# CITY OF PORTLAND BUILDING PERMIT

Job ID: 2011-02-404-ALTCOMM

has permission to Renovate Units B & C, common areas for temporary in-law situation, update insulation, kitchen & basement provided that the person or persons, firm or corporation accepting this permit shall comply with all of the provisions of the Statues of Maine and of the Ordinances of the City of Portland regulating the construction, maintenance and use of the buildings and structures, and of the application on file in the department.

**Jeanie Bourke - Re: 39 cumberland renovation project upgrades**

FLOOR PLANS
EXISTING AND PROPOSED
2ND & 3RD FLOOR

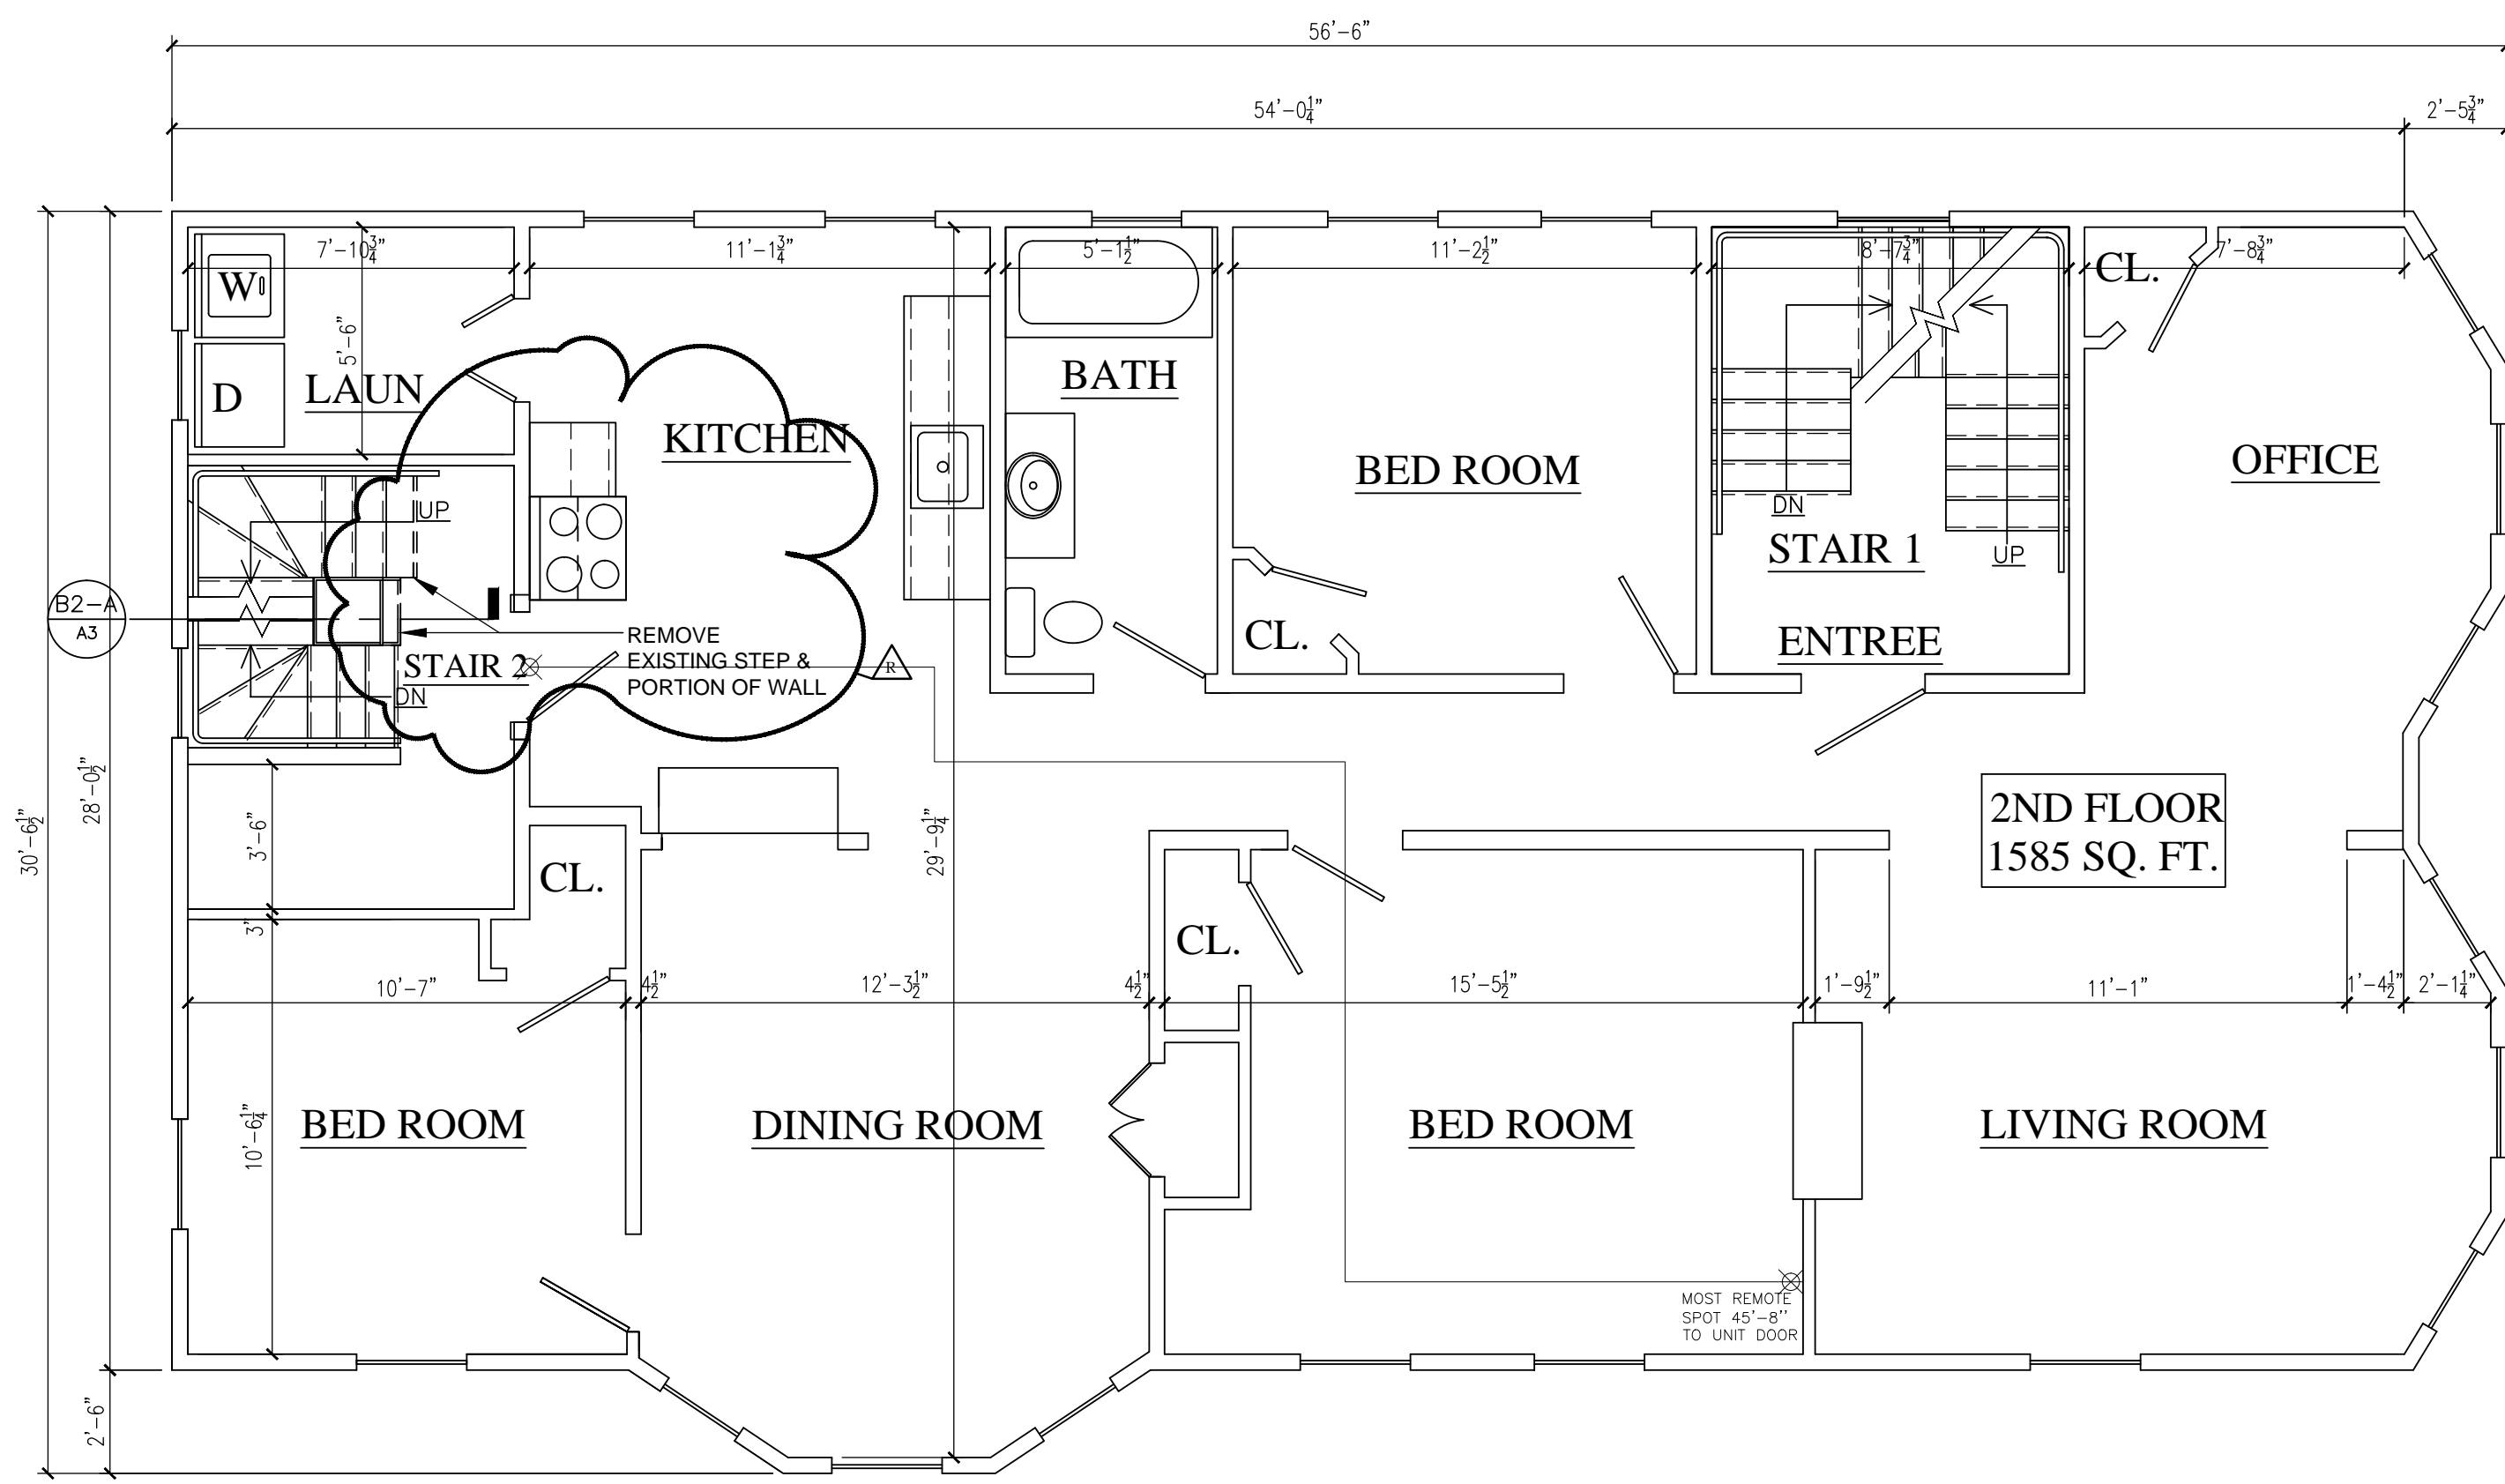
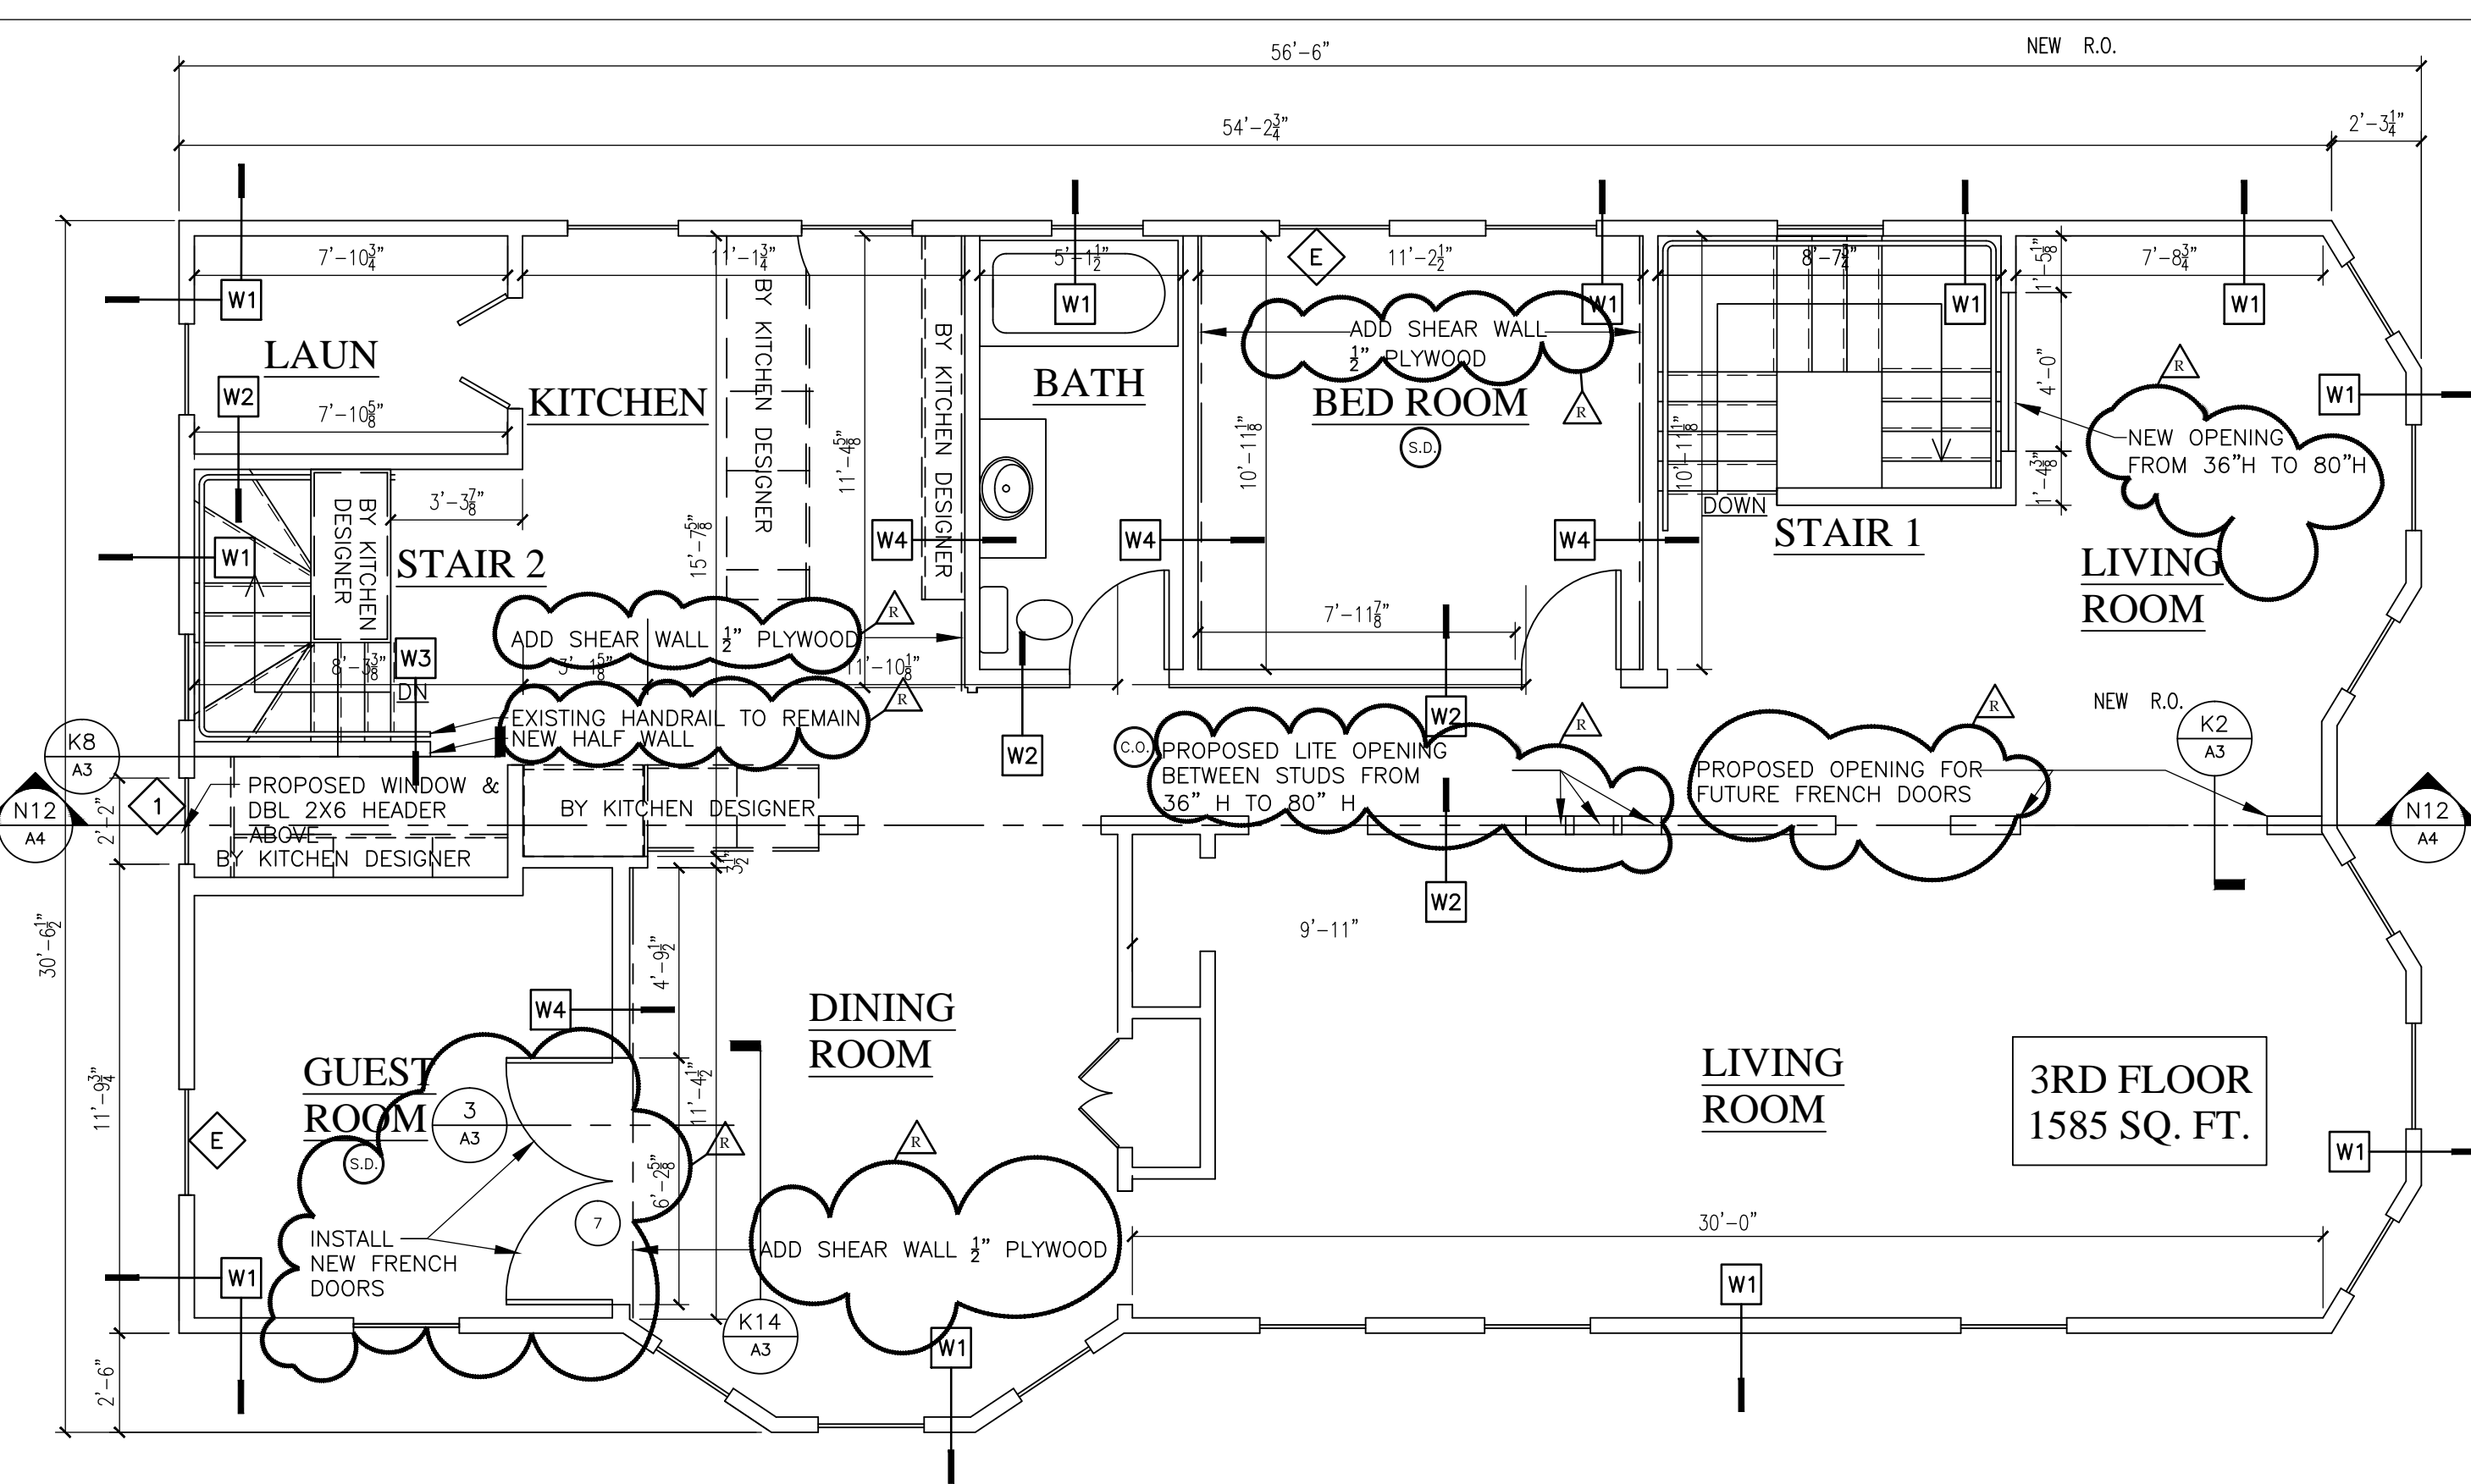
5. This approval allows the relocation of the 3<sup>rd</sup> floor rear door to the 2<sup>nd</sup> floor with the addition of a landing. A modification of IBC Sec. 1008.1.5 Floor elevation allows 1 change of elevation at the door swinging over the landing as similarly allowed in exception 1.

The only item missing that I have on my list is the height of the **relocated door at the new landing**. I believe you stated that this was an error, that the **6'-8"** dimension line should have been from the landing (not the floor) to the header. This email serves as verification of that.
